Appendix B: Agency Advice Response

CULVERT LONGITUDINAL SECTION A
310-01
 VERTICAL SCALE 1:20
 HORIZONTAL SCALE 1:500

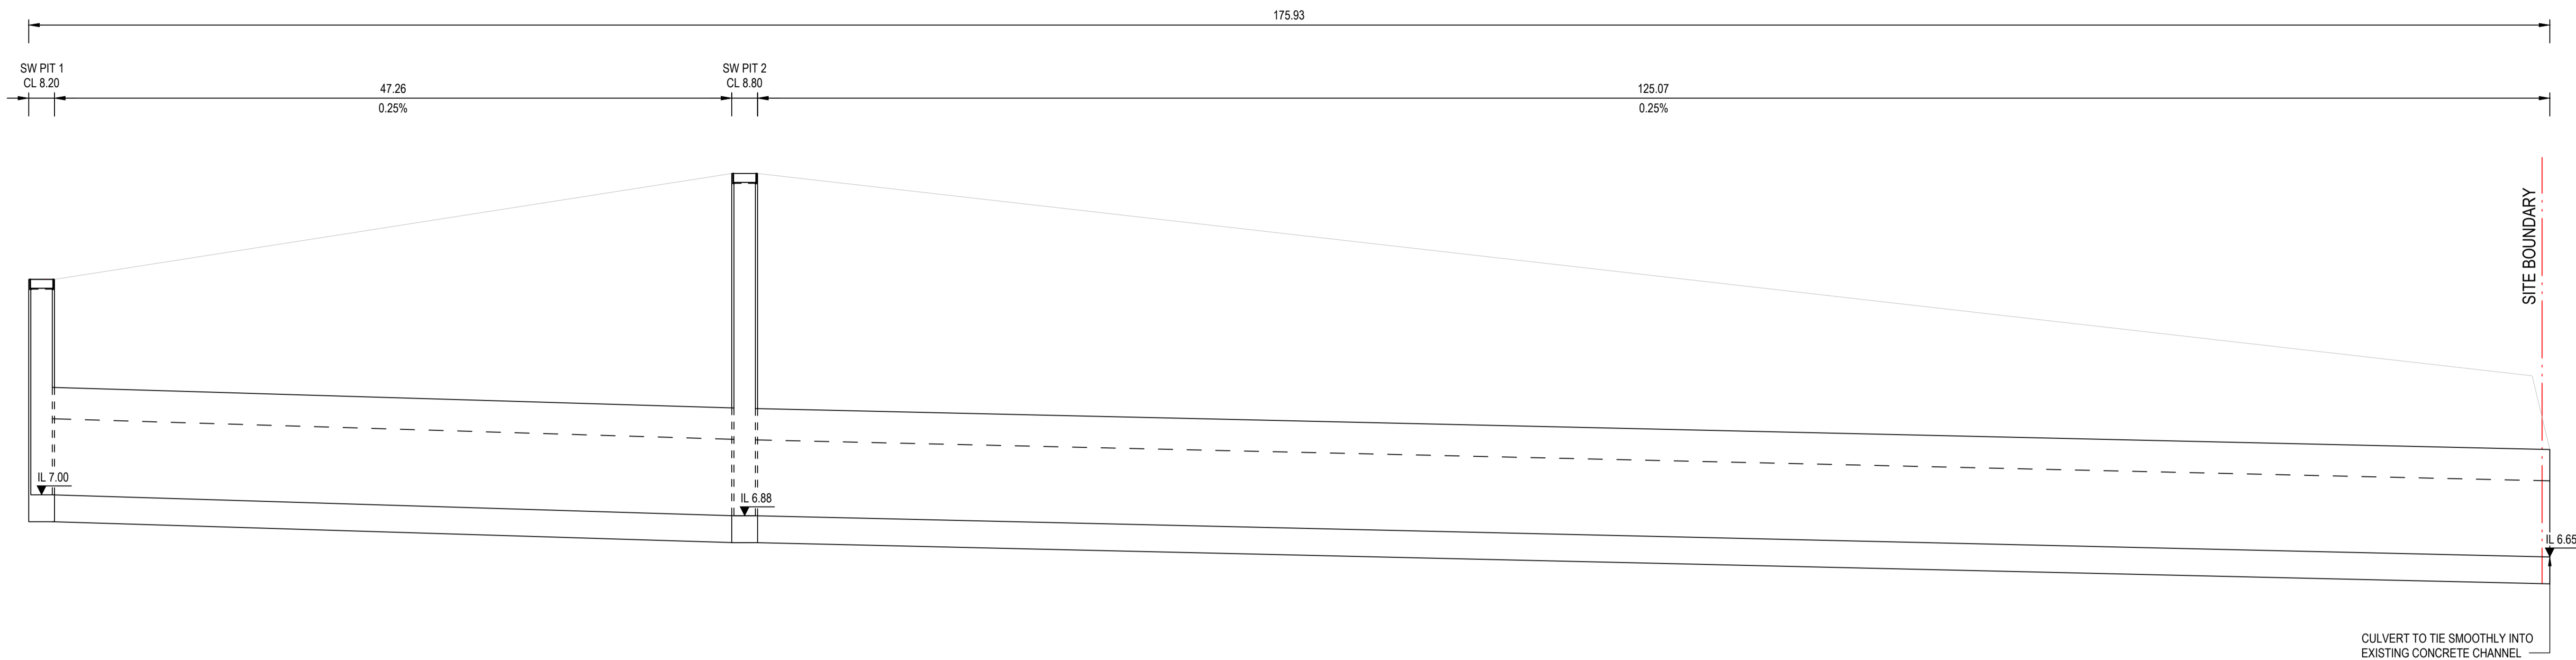
Category of Issue	Issue(s) Raised	Response/ Action
	<i>In some cases, content from submissions has been abridged or edited for brevity.</i>	
2. The risk of cars becoming mobile and blocking drains	<p>The Flood Risk Impact Assessment, prepared by Torrent Consulting has not assessed CPHR’s concerns of cars becoming mobile and blocking drains.</p> <p>Recommended action: Evaluate the risk and potential impact to property and life upstream of the stadium from vehicle-related blockages of channels and culverts.</p>	Only in flood events exceeding the 1% AEP 2050 condition will present a risk to vehicles within the car park becoming mobilised. It is highly unlikely that vehicles would be present on site during such an event and the risk of structure blockage associated with the mobilisation of vehicles within the site is negligible.
Hunter Water		
Stormwater	<p>Hunter Water will not permit the existing culvert to remain in its current location and the development to build over it. It is critical that the proponent ensures that the realignment of this stormwater culvert around the amended development footprint is technically feasible.</p>	The development proposes the realignment of the culvert to ensure the asset is not built over. As above, the existing grades are generally maintained and a culvert long section has been provided as part of the revised civil package.

Figure 3 – Site Entry & Exit Bus Swept Paths - Turton Rd

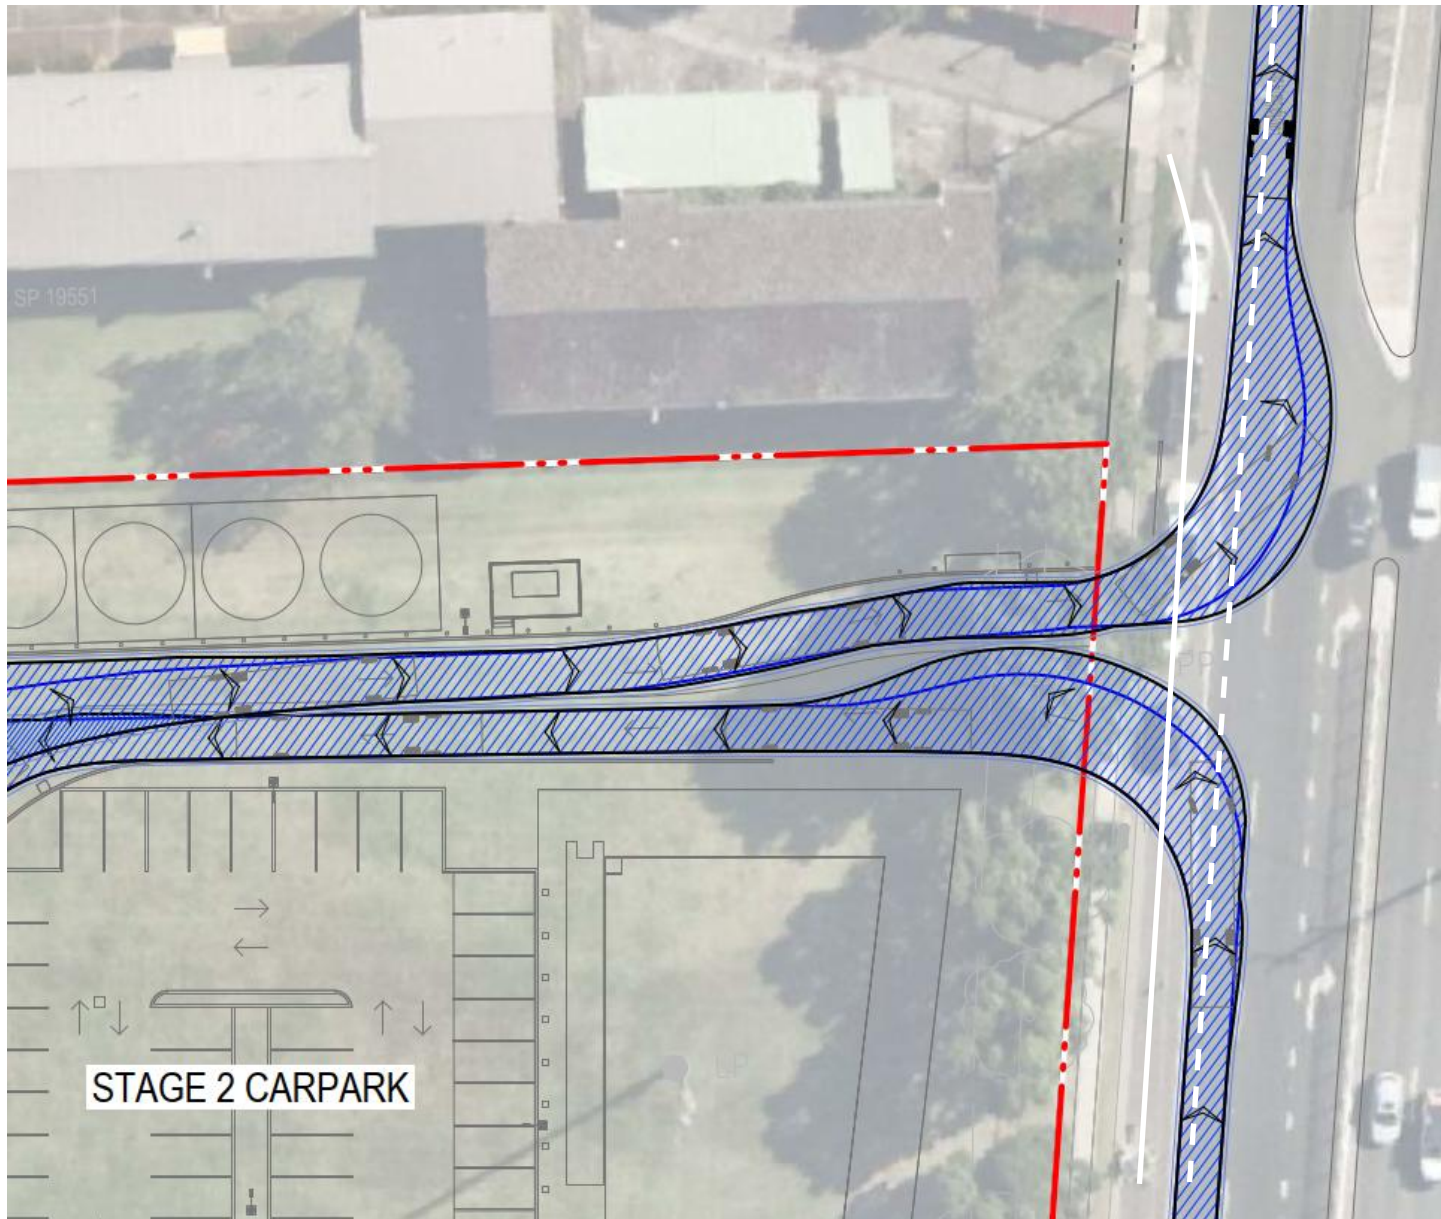
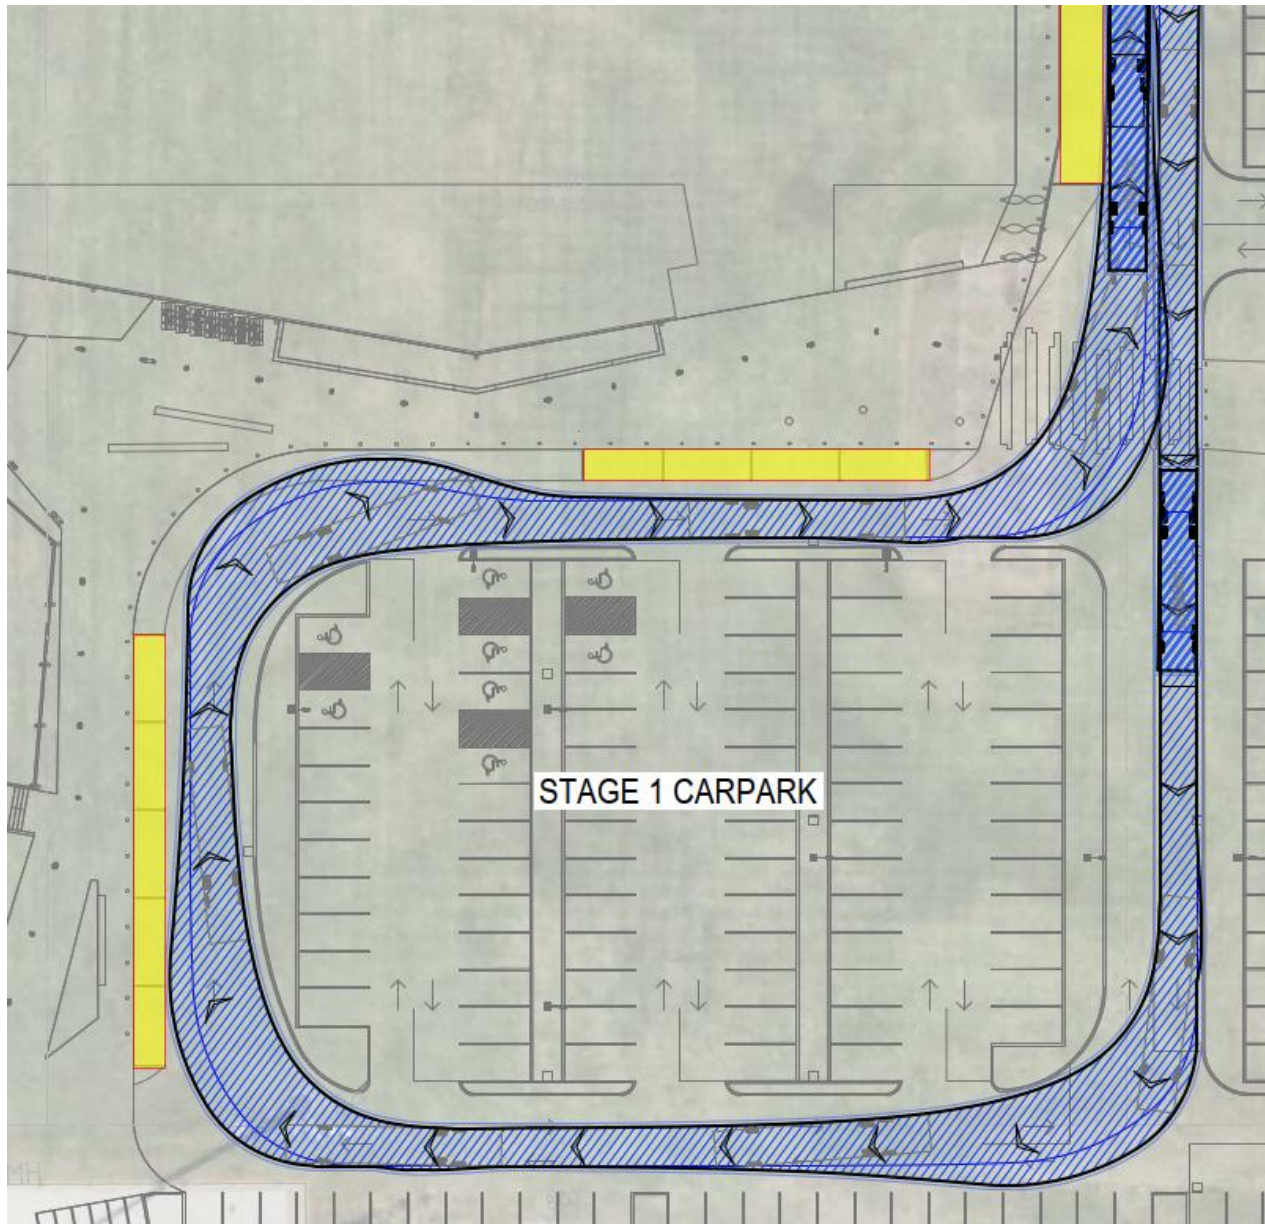
Category of Issue	Issue(s) Raised	Response/ Action
	<p><i>In some cases, content from submissions has been abridged or edited for brevity.</i></p>	<p>Based on the above, it is considered the design provides safe and practical access, circulation, and egress for buses.</p>
	<p>Clarify how the parking rate of 3-4 patrons per vehicle for events was arrived at. Note that Council has used a lower per vehicle occupation rate in their assessment.</p>	<p>The car occupancy was provided as a range of 3 -4 people per vehicle based on the professional judgement of the project traffic consultant, SECA Solution.</p> <p>The Newcastle DCP nominates a rate of 1 space per 3 visitors/seats for entertainment and community centres, 1 space per 4 seats for Places of Worship, 1 space per 5 seats for a restaurant or café and merit-based assessment for recreation facility. The parking rate of 3-4 patrons per vehicle was also applied in the Hillsborough Basketball site TIA.</p> <p>The rate of 1 car space per 3 patrons would represent a conservative rate without site specific considerations relevant to the HISC, including access to public transport, Uber/taxi drop off, being dropped off by families or friends given the convenience of the facility within the centre of the Newcastle area and again for these larger events shared travel with groups including families attending together.</p> <p>Car occupancy rates increase when parking is constrained as will occur during larger events, as does the use of alternate travel options. Similarly higher car occupancy occurs when events are licensed eg horse racing events and concerts. On this basis the 3-4 patrons per vehicle is considered a valid rate.</p>

Figure 5 – Additional Bicycle Parking Spaces

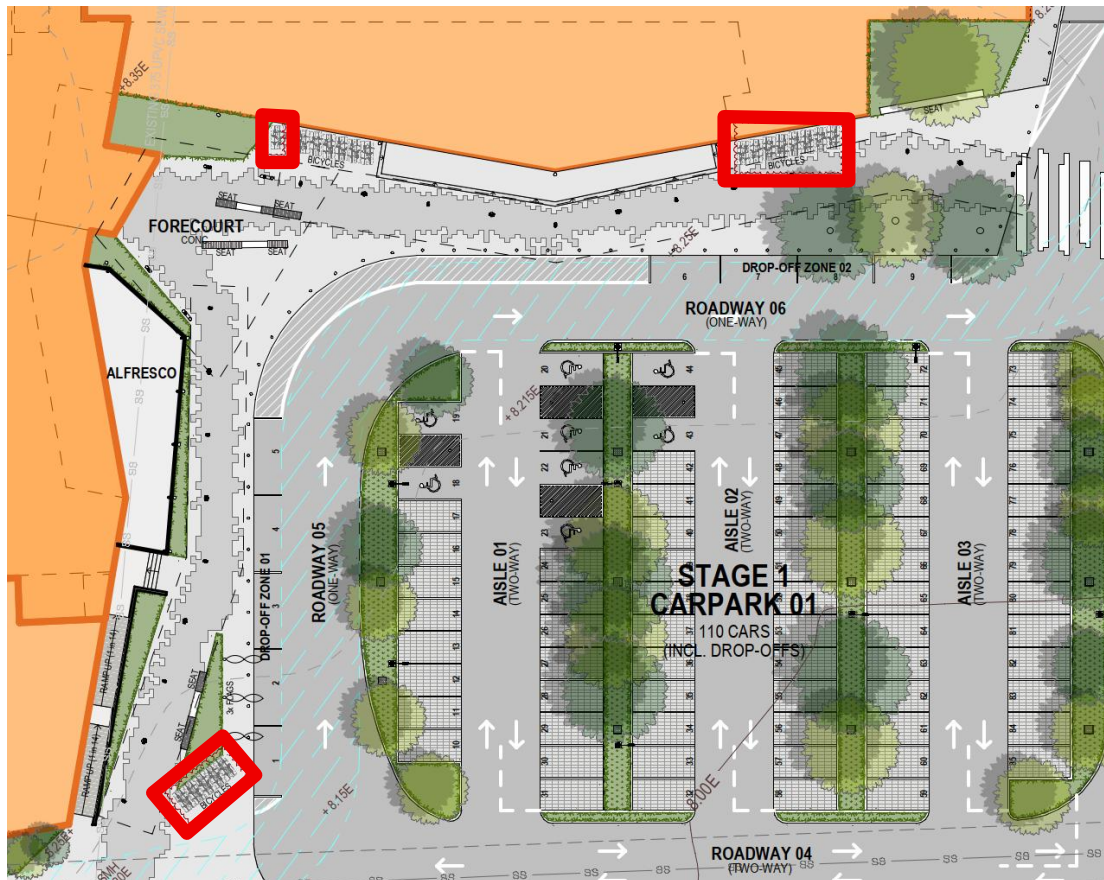
<p>Bicycle parking is to be increased to better align with the proposed patron numbers and minimise reliance on vehicles.</p>	<p>28 extra bicycle spaces have been added, providing a total of 42 external bike spaces, and 8 internal bike spaces. These are located as follows:</p> <ul style="list-style-type: none"> ▪ Two (2) extra bike spaces have been added to the previous bike area. ▪ Ten (10) extra bike spaces added near the motorbike parking <p>Sixteen (16) extra bike spaces have been added near the promenade internal roadway crossing</p>

Figure 43 - Ground Floor Permeability (bright-blue mark-ups)

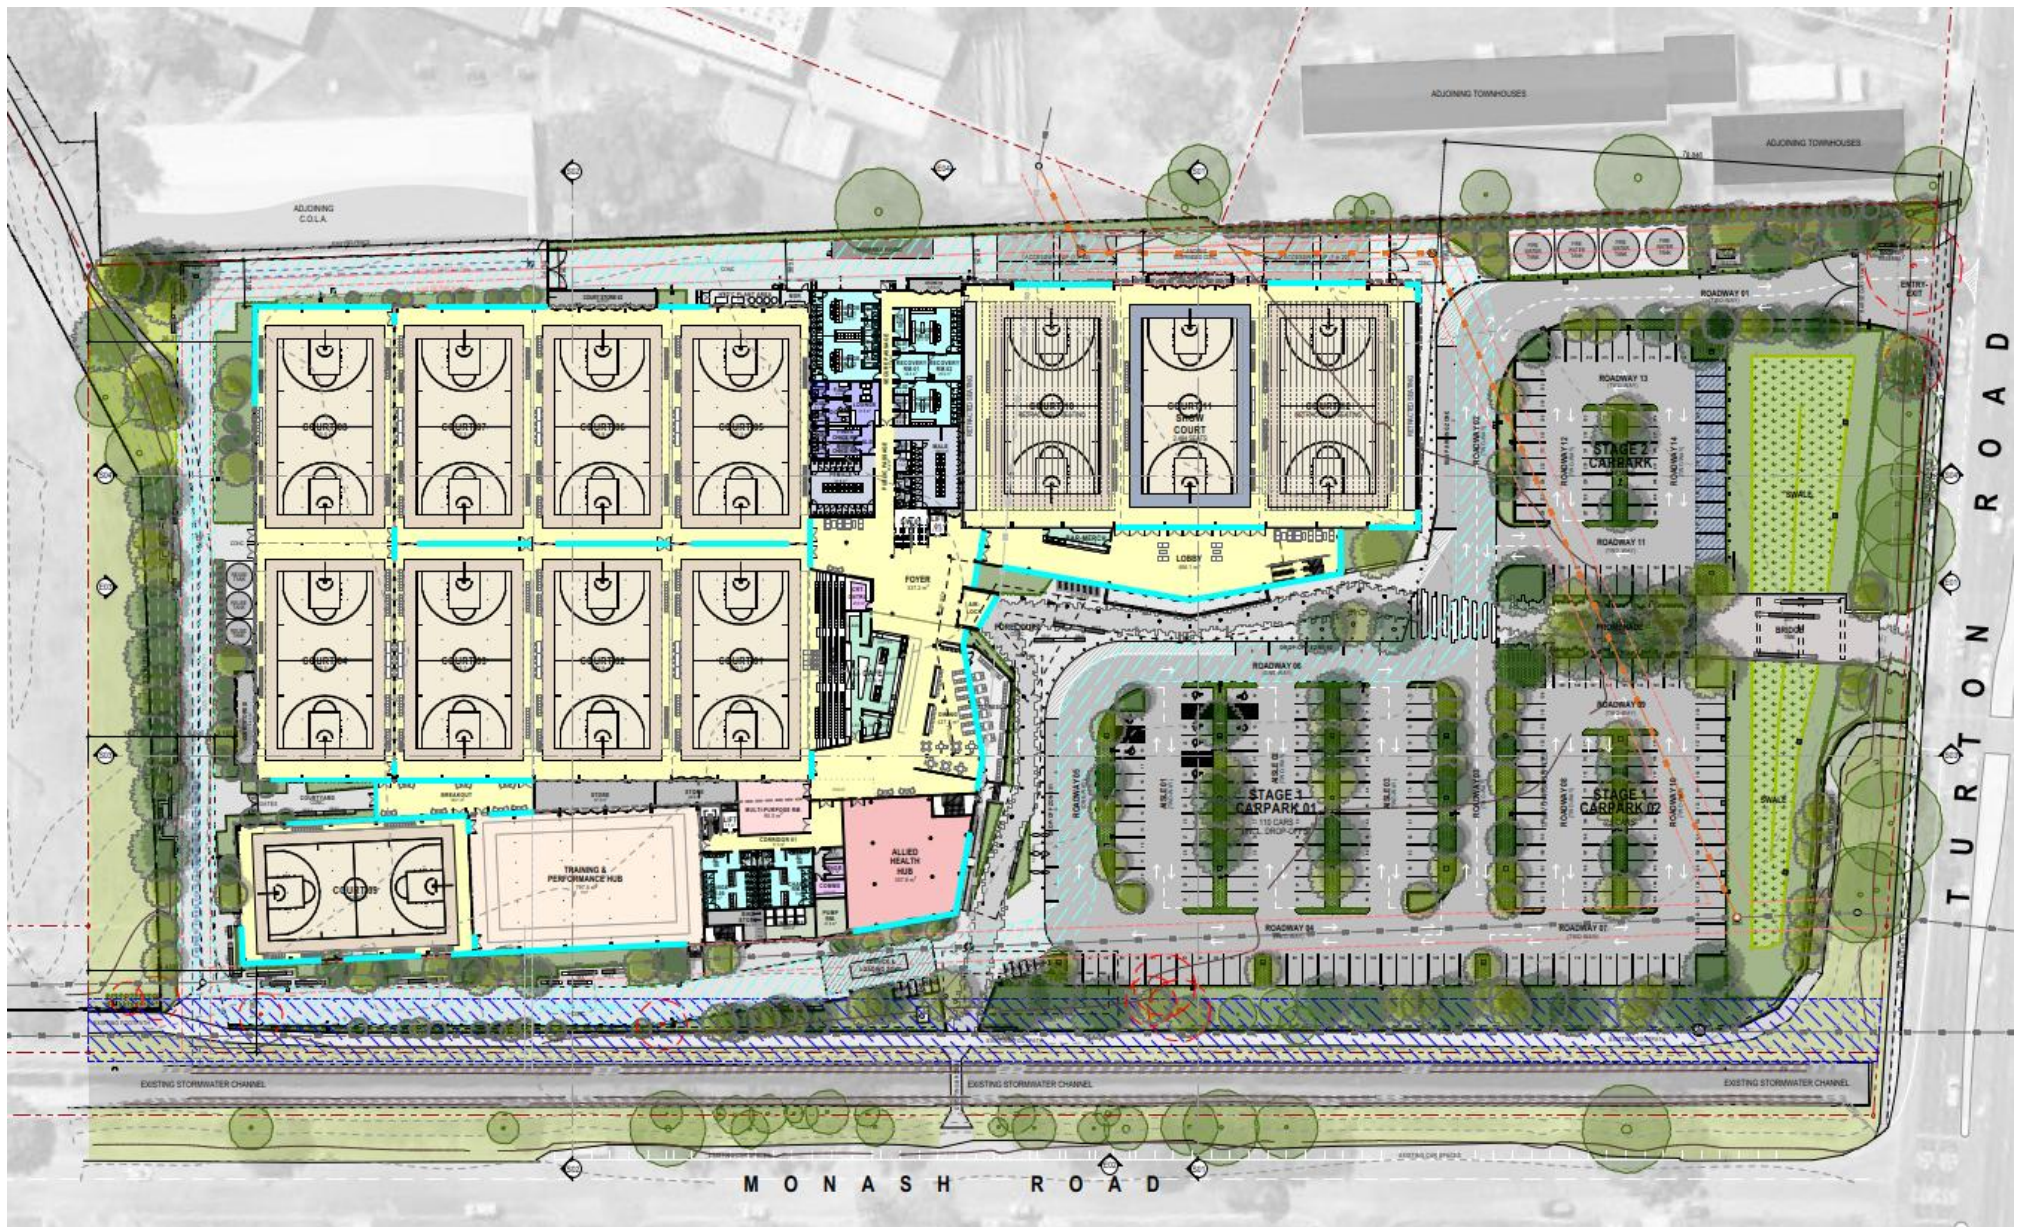
Category of Issue	Issue(s) Raised	Response/ Action
	<i>In some cases, content from submissions has been abridged or edited for brevity.</i>	
	<p>The building remains internalised with limited passive surveillance or public facing uses along the Monash Road frontage. Provide further meaningful activation and permeability along this edge of the site.</p>	<p>The facility is necessarily internalised due to its stadium function. Notwithstanding, the design incorporates substantial external and internal glazing and louvres to support passive surveillance and permeability. The southern façade facing Monash Road is largely glazed or permeable at ground level, with this approach clarified through additional drawings and updates in the first RTS.</p> <p>Activation of the façade facing Monash Road is constrained by existing infrastructure and landscape buffers. Further permeability would conflict with Council requests for increased landscape screening. It may result in adverse acoustic impacts.</p>
